# CITY OF ALBUQUERQUE

RE: **Sunset Gardens Apartments**  
**86<sup>th</sup> and Sunset Gardens SW**  
**Grading Plan Stamp Date: 10/3/18**  
**Drainage Report Stamp Date: undated, 9/18**  
**Hydrology File: L10D032**

Based on the submittal received on 10/3/18, the Grading Plan and Drainage Report cannot be approved until the following are corrected and a complete resubmittal is made:

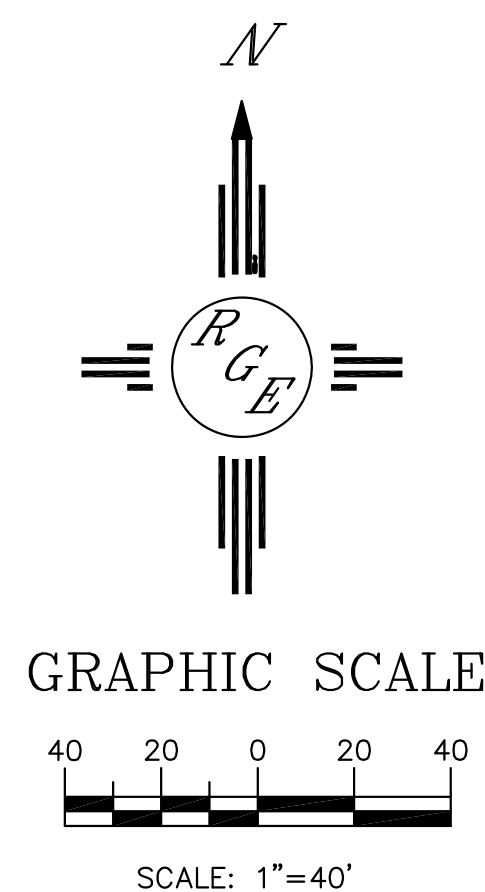
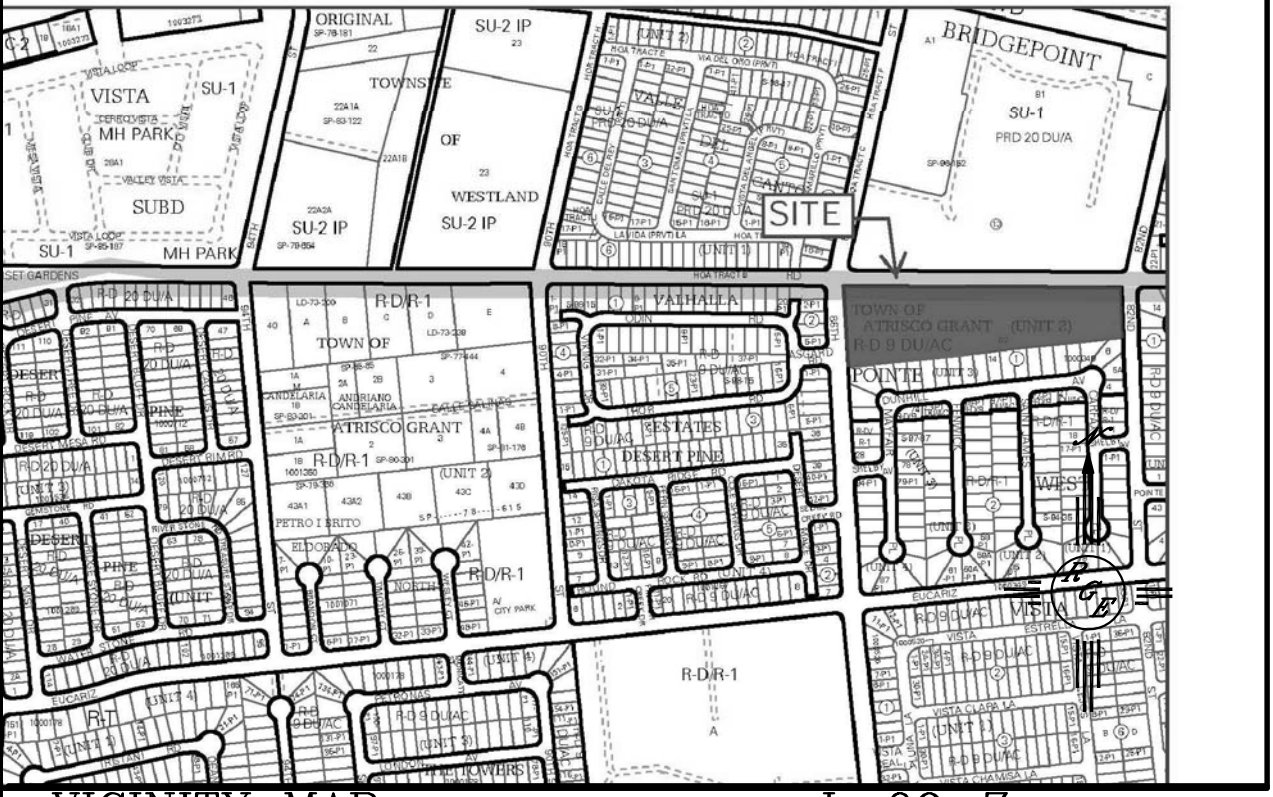
1. Provide a full size subbasin map; annotations are illegible on the small size provided and additional detail is required:
  - a. Define (hatch) the areas of impervious vs. pervious land cover.

- b. Delineate the areas draining to each first flush pond and quantify the required vs. provided volume for each (include supporting calcs in the Report).

- c. Basin F is ROW and drive entrance and can be exempt from the first flush ponding requirement.
2. Correct the following errors and typos in the Drainage Report:

4. Add proposed contour labels and existing minor contour labels.

5. Should there be a valley gutter or something to convey the flow from the western Basin E pond down to the D-inlet? Also, it seems like underground storage in the vicinity of the D-inlet would be a more effective way to capture all the imperious area runoff, especially if the roof runoff can be directed to the internal drive aisles.

6. Add note on the plan that “No work shall be performed in the public ROW without an approved Work Order or Excavation Permit.”
7. The following drainage infrastructure needs to be listed on the Infrastructure List:

- a. The single-A inlet on 82<sup>nd</sup> St. This connector pipe will need to be 18” RCP, not 12”; if there’s a 12” stub, it’ll need to be replaced to the manhole with 18”.

- b. The new single-A inlet and type-E manhole on Sunset Garden.
  - c. The new sidewalk culvert on Sunset Garden.
  - d. Additional drainage infrastructure may be identified, pending final approval of this plan.

8. Provide cross sections, one for each road/property line and at the points of maximum retainage. Include retaining walls and footers, property/ROW lines, existing and proposed grades, horizontal and vertical dimensions, and proposed ROW improvements such as: sidewalk, curb and gutter, and paving.
